## SPR EA1N and EA2 PROJECTS

### DEADLINE 5 - RESPONSES TO APPLICANTS COMMENTS AT D4 ON SASES WRITTEN REPRESENTATIONS SUBMITTED AT D1

Interested Party: SASES    PINS Refs: 20024106 & 20024110

Date: 3 February 2021

m

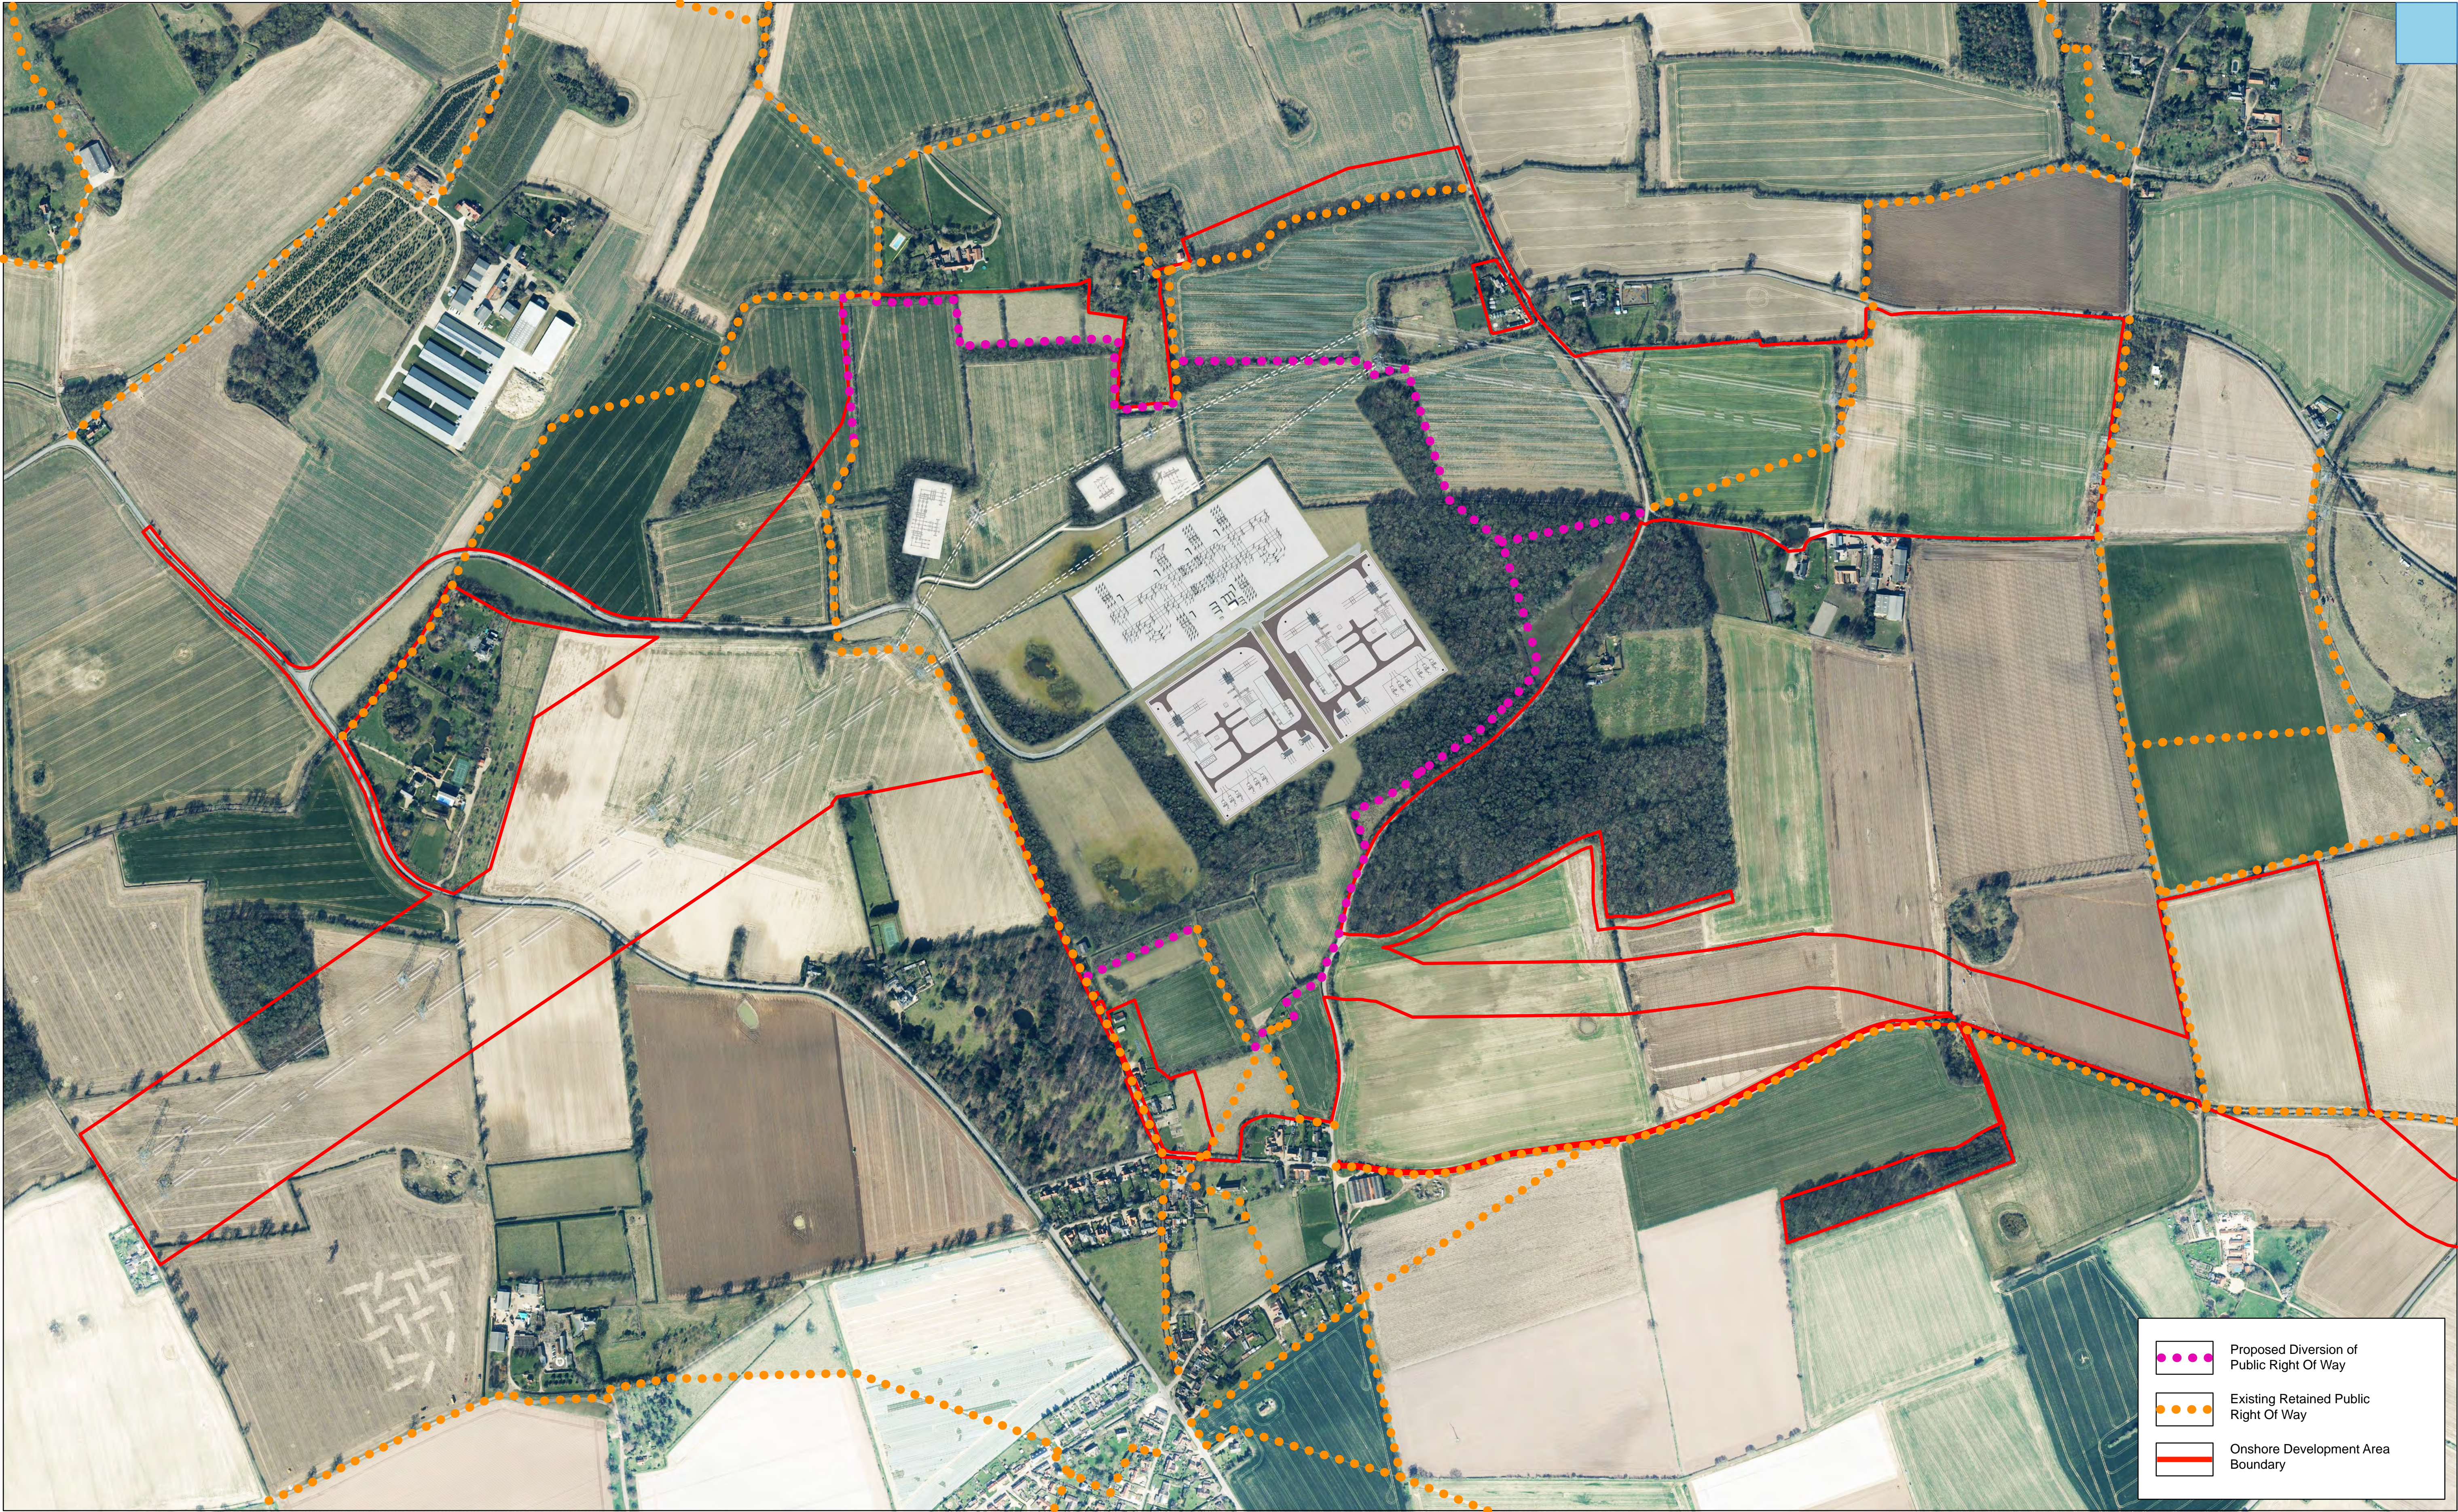
- 
4. As noted in *EN010077-003208-sases deadline 3 mb 1080 BN04 Landscape 151220* whilst the commitment to install the ducting for both projects at once along the cable route is welcomed no such commitment has been given with regard to the substations although it would clearly be a potential mitigation measure with regard to the adverse landscape and visual impacts at Friston. As a consequence, the uncertainty over both the length of the construction period and the date on which the vast majority of the mitigation planting can be implemented remains.

7. It is welcomed that the revised photomontages in the Appendices to the *Landscape and Visual Impact Assessment Addendum* now include an existing image that can easily be compared to the photomontages and that the overly optimistically 'early' planting has been omitted. It is a shame that the opportunity was not taken to revise the smooth green field with the newly planted whips/transplants in Vp 1 which, as pointed out at the ISH2, is quite unrealistic. Creating a more realistic image which acknowledged the likely soil conditions around the planting would not have been difficult. Vp 1 is also a very clear example of the limitation of the approach to showing just Yr 1 and Yr 15. The Yr 1 image is quite unrealistic and there is no real indication of how that viewpoint will look over the period that it will take for the planting to establish.
